From: Gale Violette
Sent: Wednesday, July 12, 2023 1:42 PM
To: wtsatterfield@gmail.com
Subject: The Perk on Broad

Good afternoon. I received your updated application and floor plan today. I have a few items I need before I can proceed with the plan review:

FLOOR PLAN - OPTION A 1  
 1/4" = 1'-0"

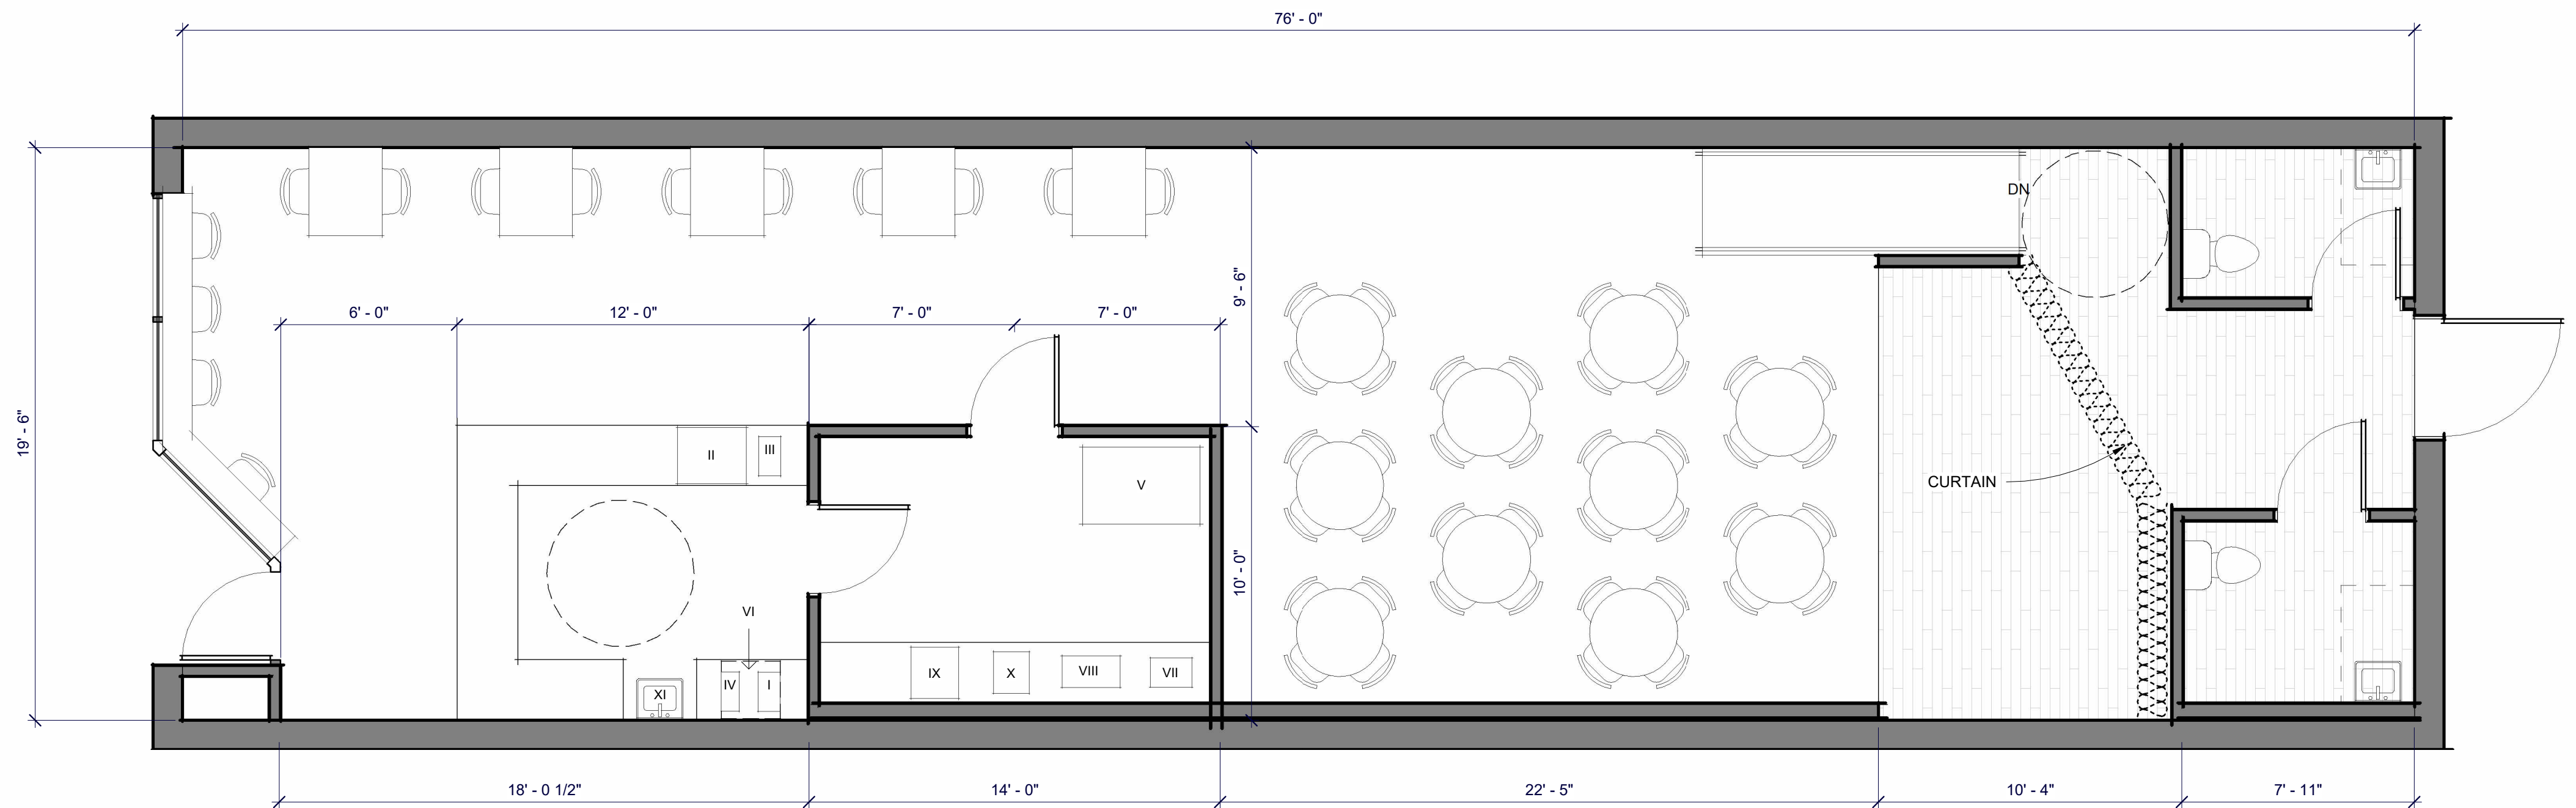
1. Provide equipment specification sheets for each piece of equipment.
2. There are no utensil washing or storage equipment shown on the plan.
3. There is no dry storage space indicated on the plan.

6. Will you buy bulk meat and slice on site or will it be pre-sliced?
7. Is there a designated food preparation sink to wash fruits and vegetables?
8. You indicated that you will provide an AutoChlor single-rack dishwasher. Provide specification sheet for the dishwasher.

9. All air-drying shelving must be labeled on the floor plan.
10. Provide a floor plan showing mechanical, plumbing and lighting.
11. Show a site plan showing the can wash and dumpster areas.
